17th October 2023

**TOWN AND COUNTRY PLANNING ACT 1990 NON-MATERIAL AMENDMENT PLANNING TO APPROVAL
22/01144/F OS Parcel 5700 South West Of Grange Farm, Street Through Little Chesterton,
Chesterton.**

Since the application was approved, the occupier (Siemens Healthcare Ltd) has been refining the proposed plans in order to ensure the built-out scheme meets their detailed operational requirements. This has necessitated a number of minor changes to the external and internal appearance of the building. The table below sets out the changes that are required.

13-222-SGP-500-EL-D-A-121351

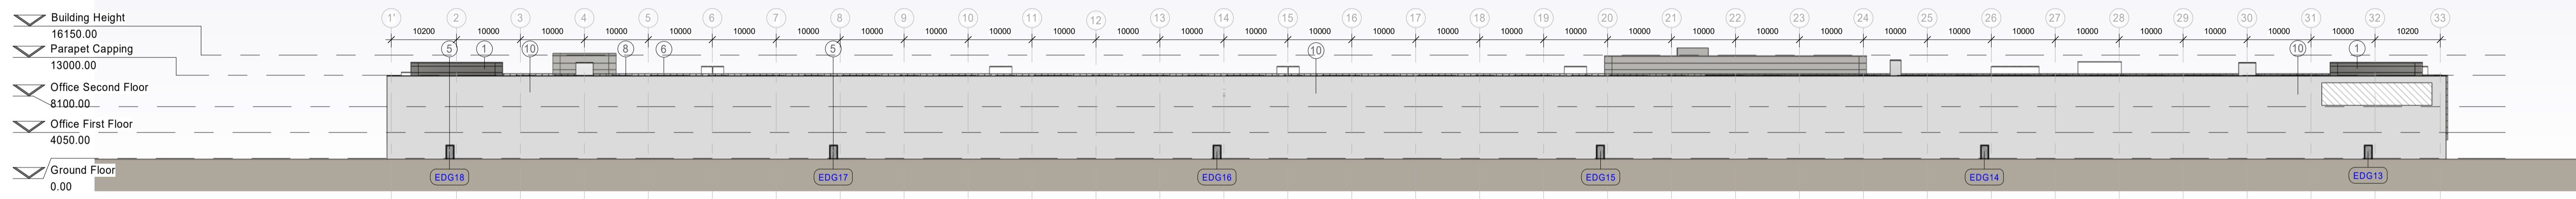
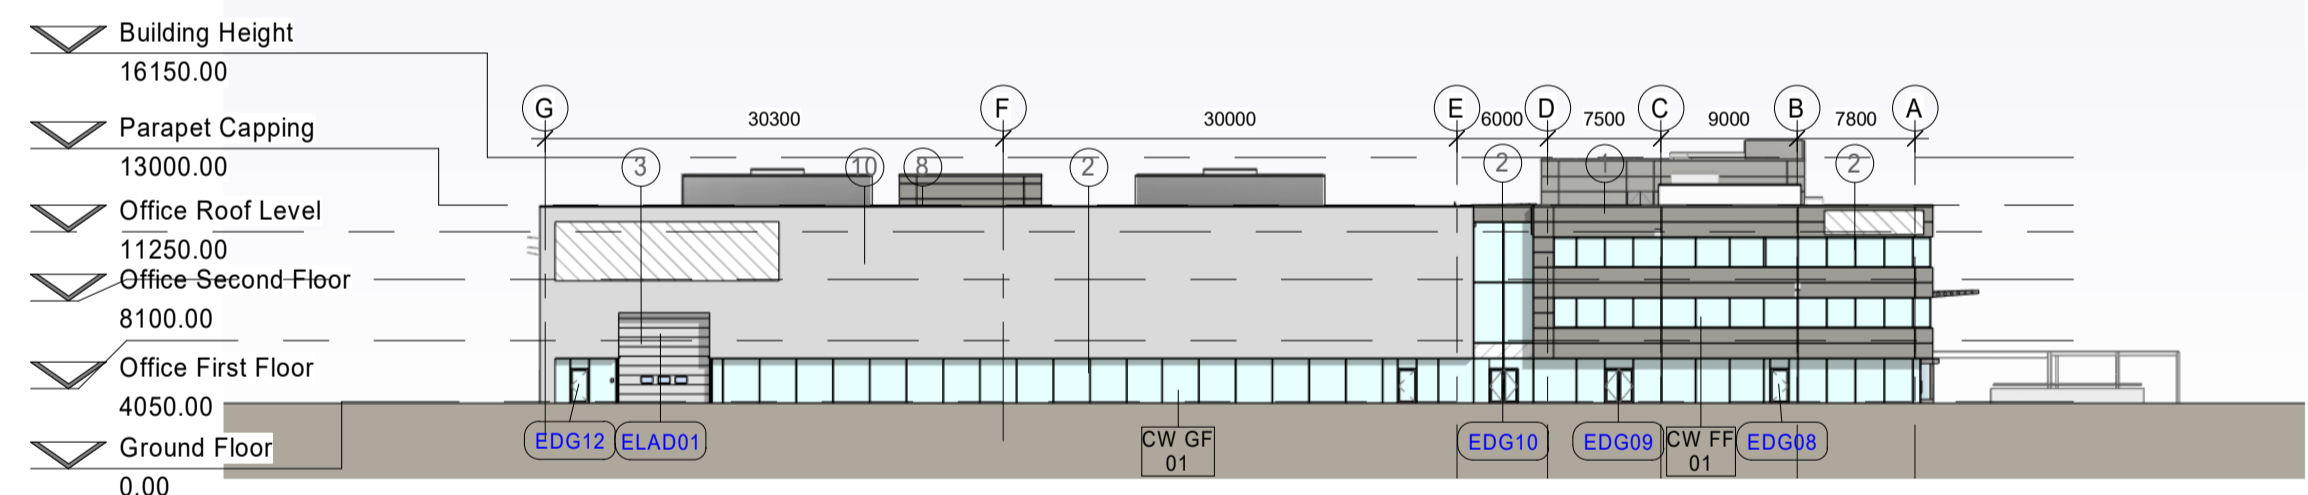
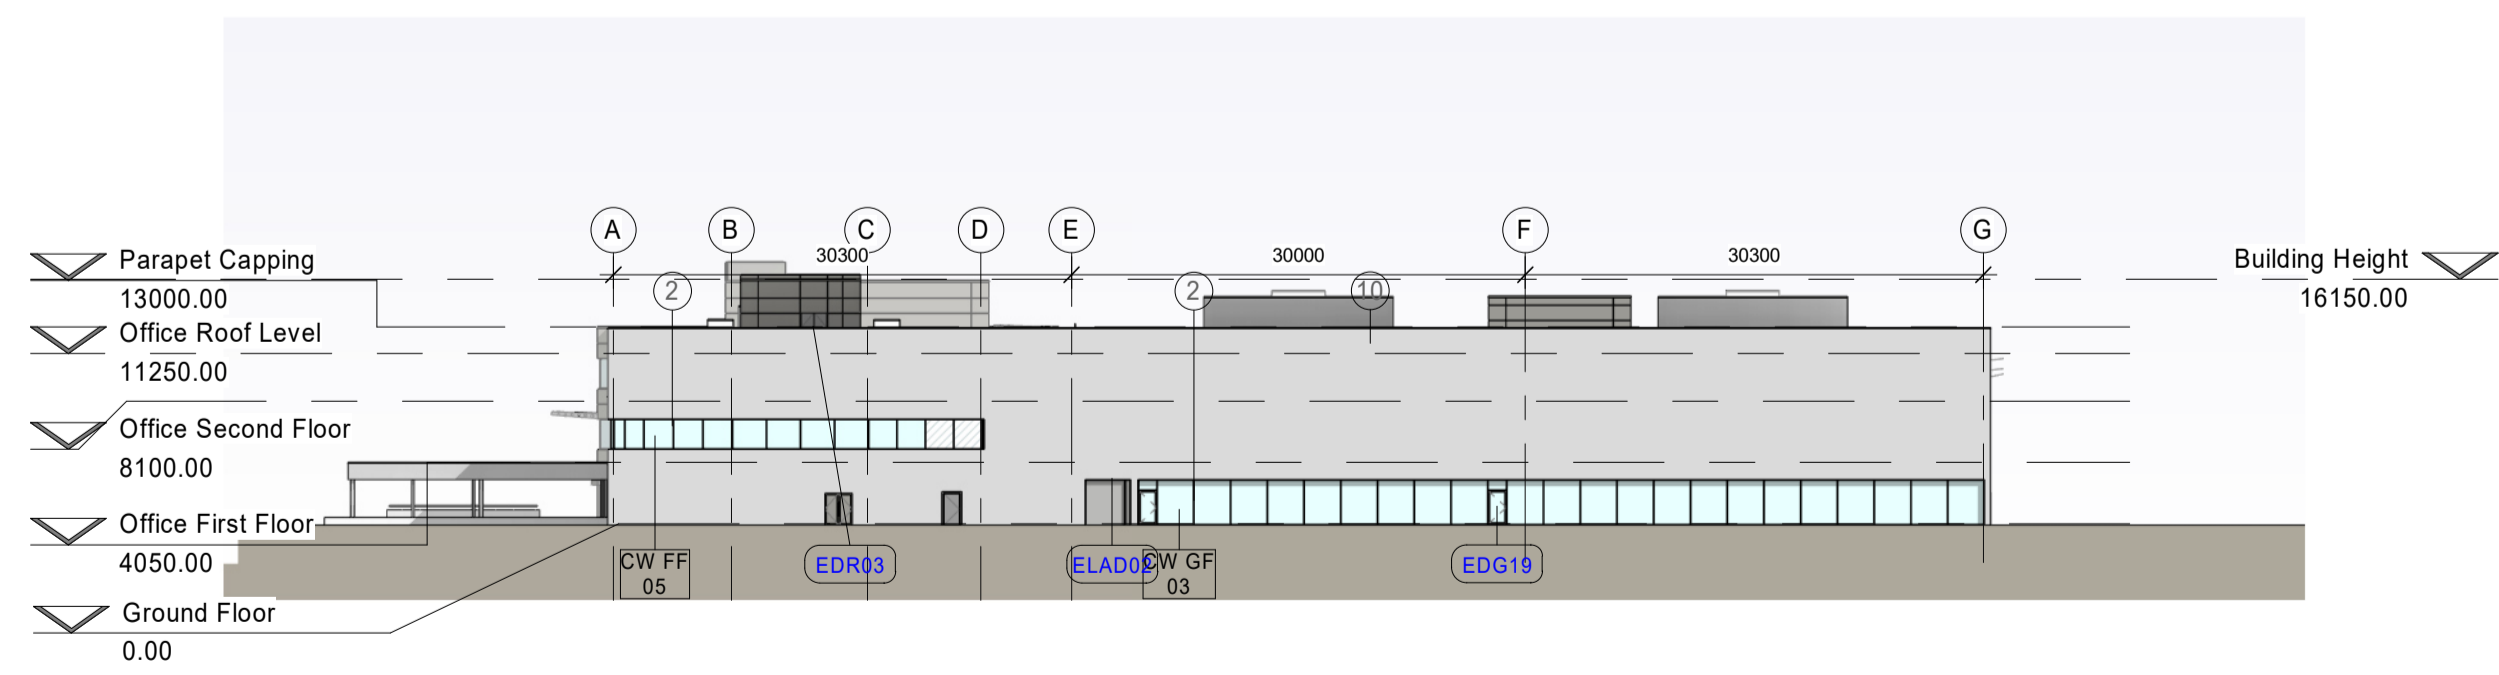
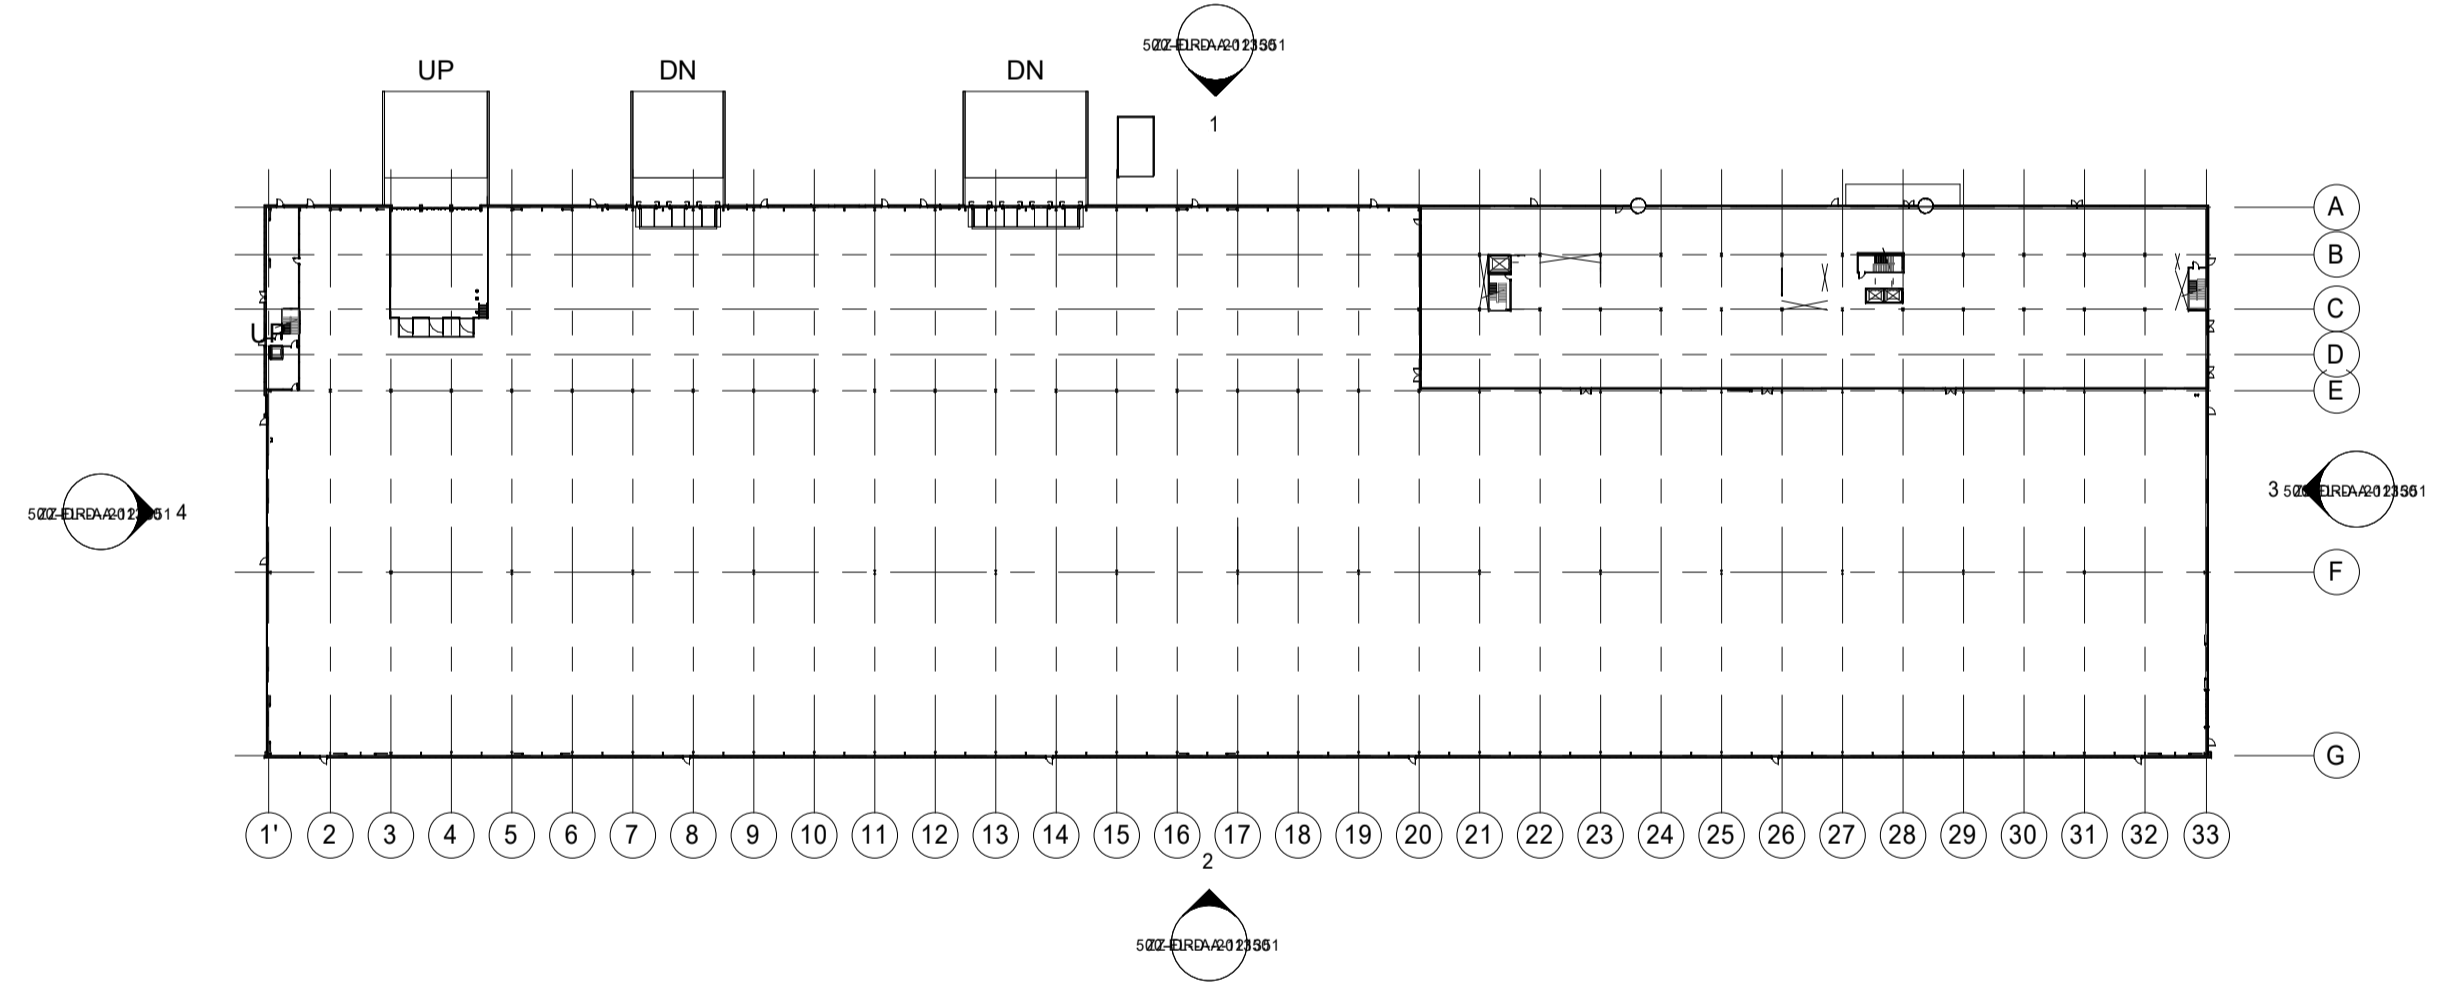
External Finishes Plan Phase 2. Drawing no. 13-222-SGP-ZZ-ZZ-DR-A-131002 REV M	External Finishes Plan Phase 2. Drawing no. 13-222-SGP-ZZ-ZZ-DR-A-131002 REV N.
Minor variations to Elevational Details.	<p>A number of minor revisions to various elevations are proposed:</p> <p><u>North East Elevation:</u></p> <ul style="list-style-type: none">• Replace built up system with composite cladding panels.• Glazed windows added to Second Floor Offices and Goods in Office.• Relocation of 1 x revolving door• Repositioning of doors/Addition of Roller doors <p><u>South West Elevation:</u></p> <ul style="list-style-type: none">• 6 x new external doors added. <p><u>South East Elevation:</u></p> <ul style="list-style-type: none">• Repositioning of doors/Addition of Double doors. <p><u>North West Elevation:</u></p> <ul style="list-style-type: none">• Repositioning of doors/Addition of Double doors.	Phase 1 Elevations 13-222-SGP-ZZ-ZZ-DR-A-131300 Rev E	Elevations 13-222-SGP-500-EL-D-A-121351 Rev P01.
